### BARNSELY MBC - Environment and Transport

These comments are in response to the hybrid planning applications 2021/1089 *and* 2021/1090.

Definitive Map Officer  
Barnsley Metropolitan Borough Council

3.4 Connectivity Strategy

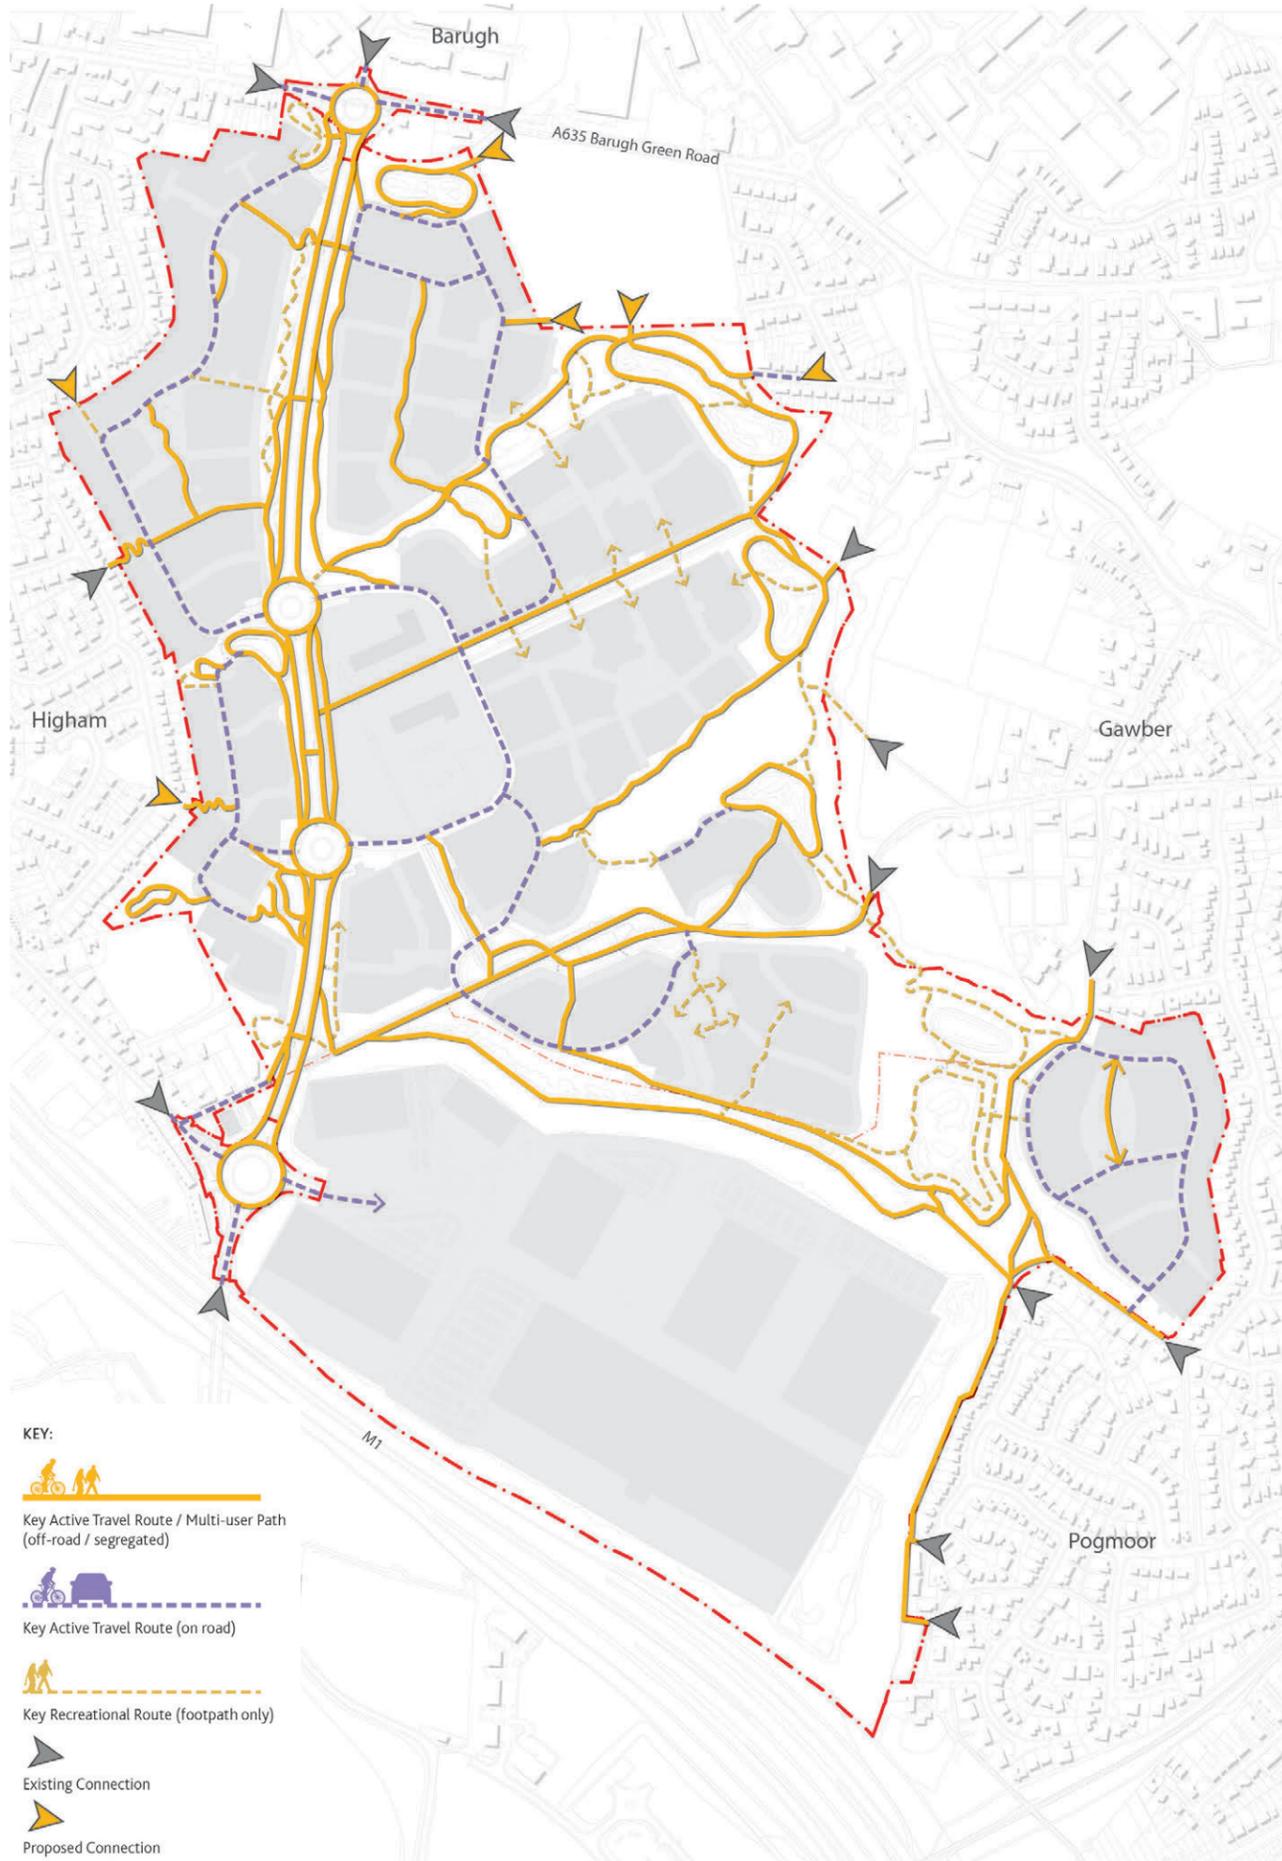
**States:** Proposed primary routes are to be a minimum of 3m wide. These are identified as multi user shared routes for cycle and foot traffic. The gradients of which vary between 1:21 and 1:14. Where level access has not been achievable due to level changes then stepped access has been introduced.

Such routes would be cycleways and the responsibility of Highways, not PROW. Must be confirmed in discussion with Highways DC and PROW.

**Also states:** Proposed secondary routes are to be a minimum of 2m wide are also multi user routes. The gradients of these routes vary between areas of flat access to areas that have gradients between 1:21 and 1:10. This type of route also includes wooden board-walks located across and around the detention basins. The existing Greenway along Hermit Lane falls within this category. This is proposed to be stopped up for vehicle access and diverted as a pedestrian / cycle link serving as an important link to Gawber.

As above for 'primary routes'.

'Informal routes' are also shown – it is unclear what this refers to. Must be clarified.

3.5.2 PROPOSED PROW NETWORK

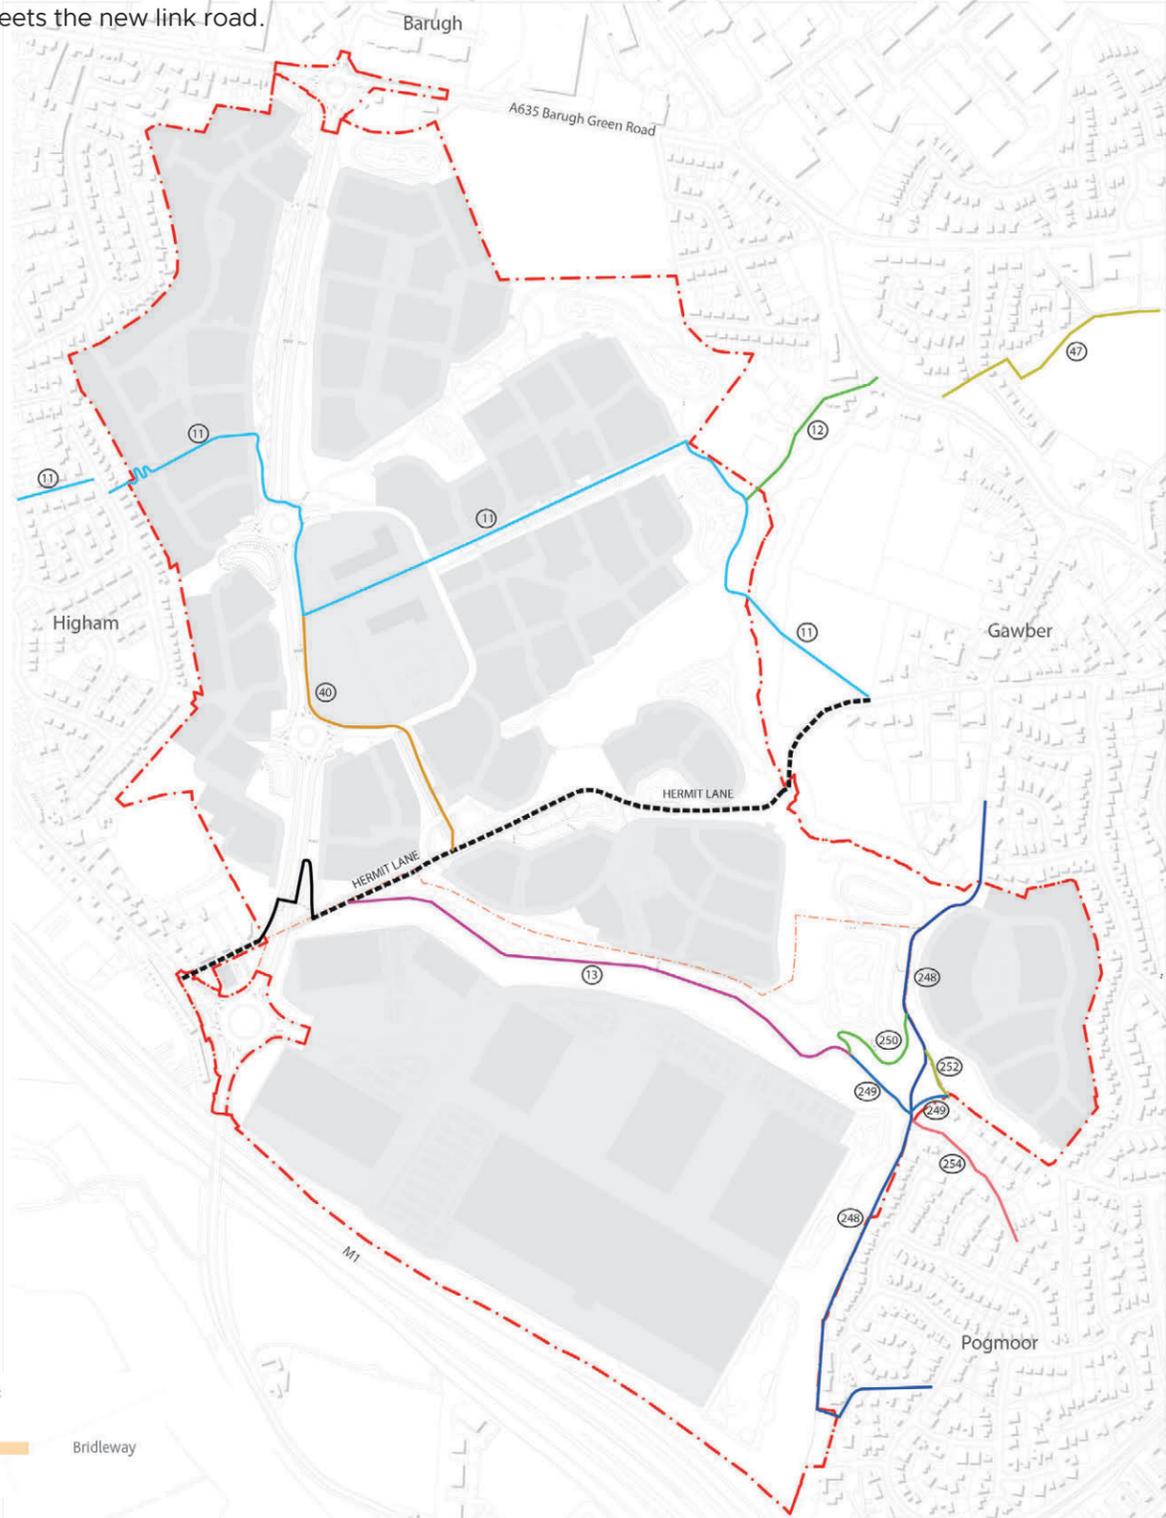
Para 3.5 Proposed PROW Access refers to a number of proposed changes. All of the new routes are subject to agreement and public consultations. They are not agreed as part of this consultation. NB: PROW would want to avoid the zig-zag alignments, loops and parallel routes shown as much as possible. Materials to be agreed.

3.5 Public Rights Of Way (PRoW)

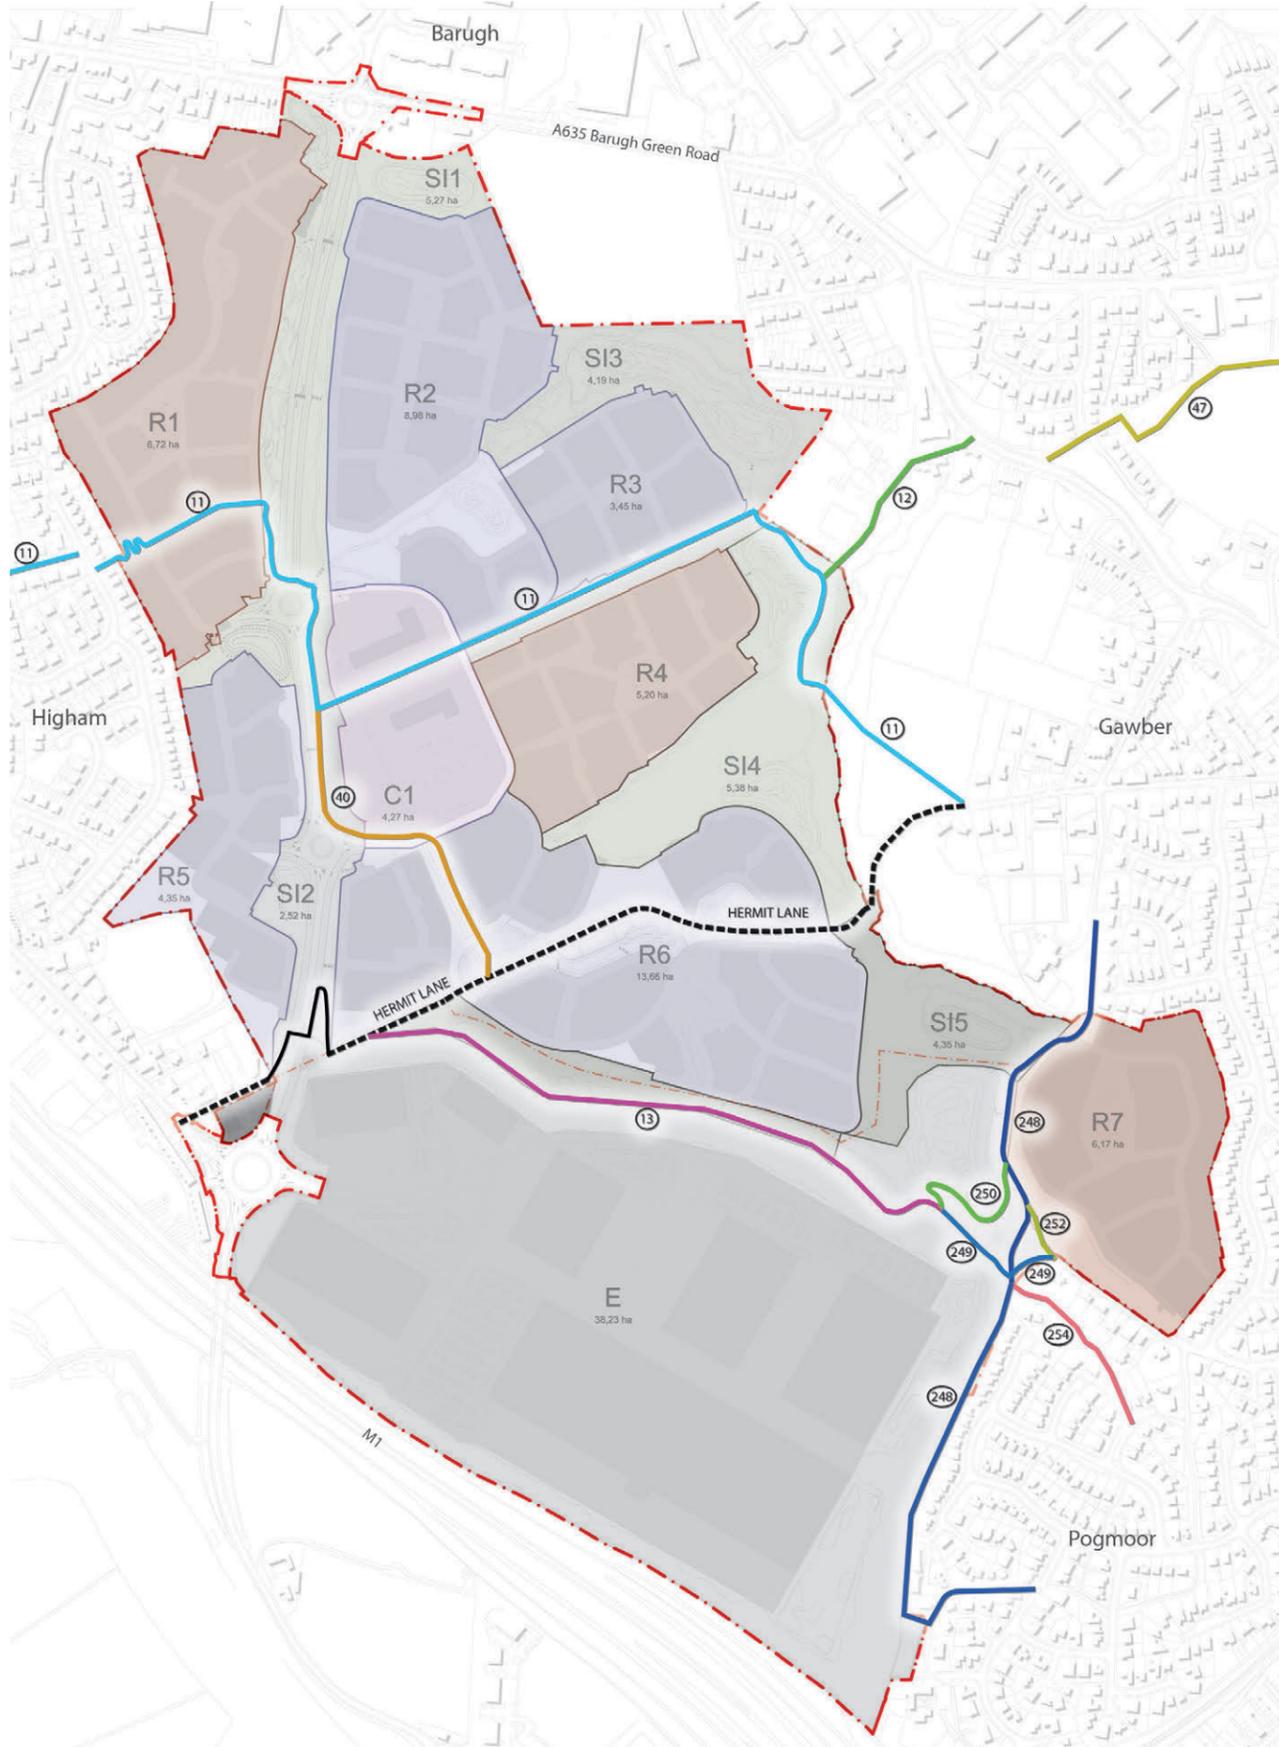
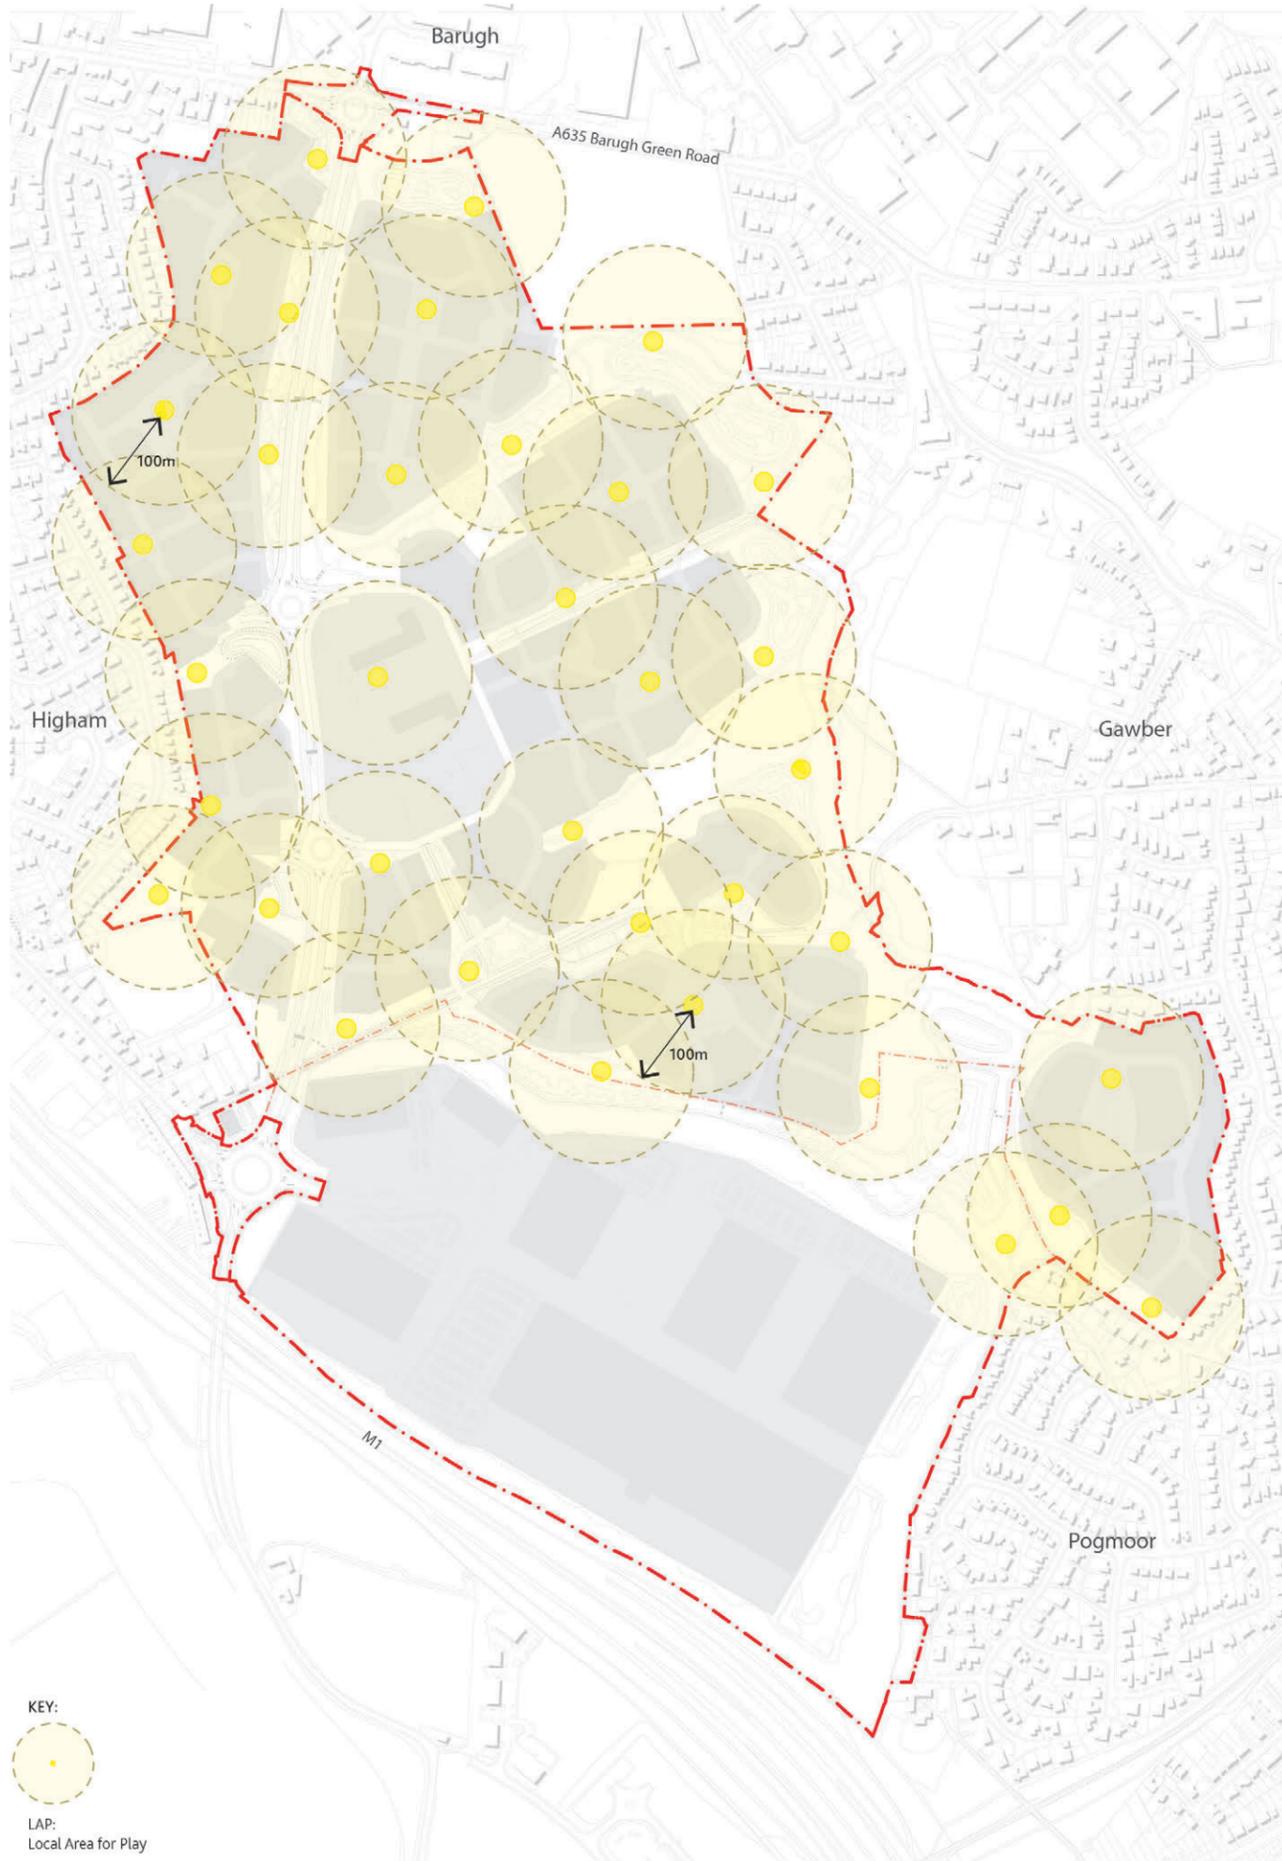
**Para 3.4 Existing PROW Access states:** Some routes require minor diversion, whilst others require full diversion such as 13, 40, 249 and 250.

Any proposed changes to the existing PROW are subject to formal diversion orders and must be agreed with PROW.

Para 3.6 Phased PROW delivery refers to PROW changes to be provided in phases 1 & 2, then subsequent phases. However, there is some crossover here that would leave some of the routes as 'dead end' routes until the end of works. More detail is / will be required on the works as part of each phase of development.
